From: Leah Llamas  
To: Robin Proebsting  
Subject: RE: Ticket ID: 58293 opened by Robin Proebsting.  
Date: Friday, February 12, 2021 10:09:52 AM

Looking through the plan sets, can the street names they are using be corrected sooner than later?

CHESHIRE SHORT PLAT

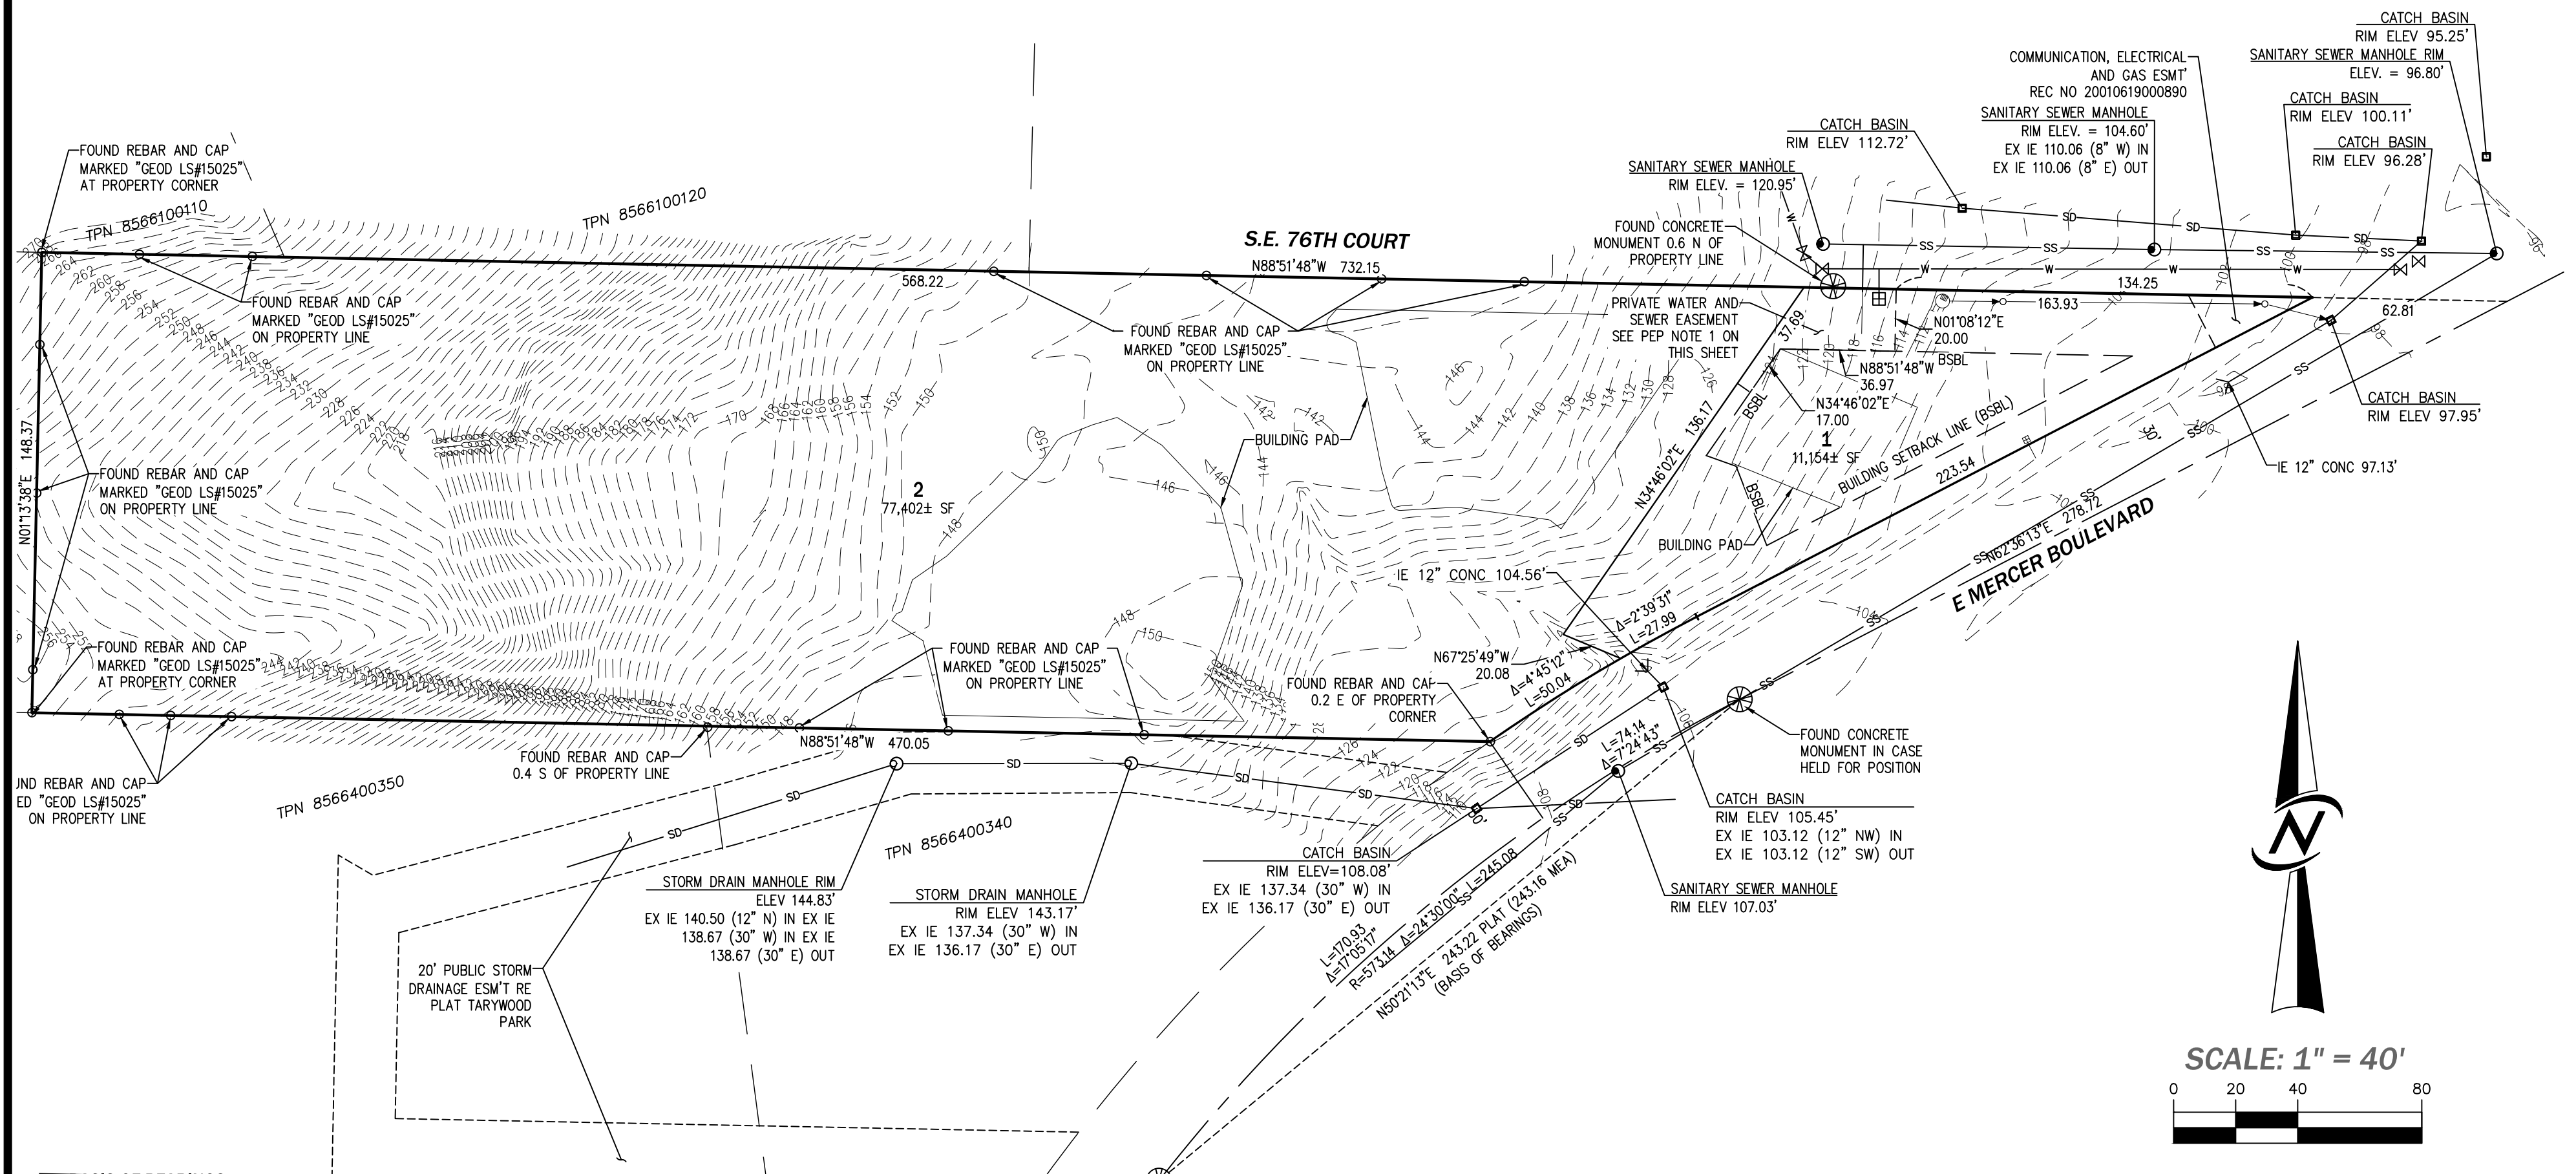
They also show E Mercer Way incorrectly as E Mercer Boulevard. Especially if this will be recorded, the street names should be correct.
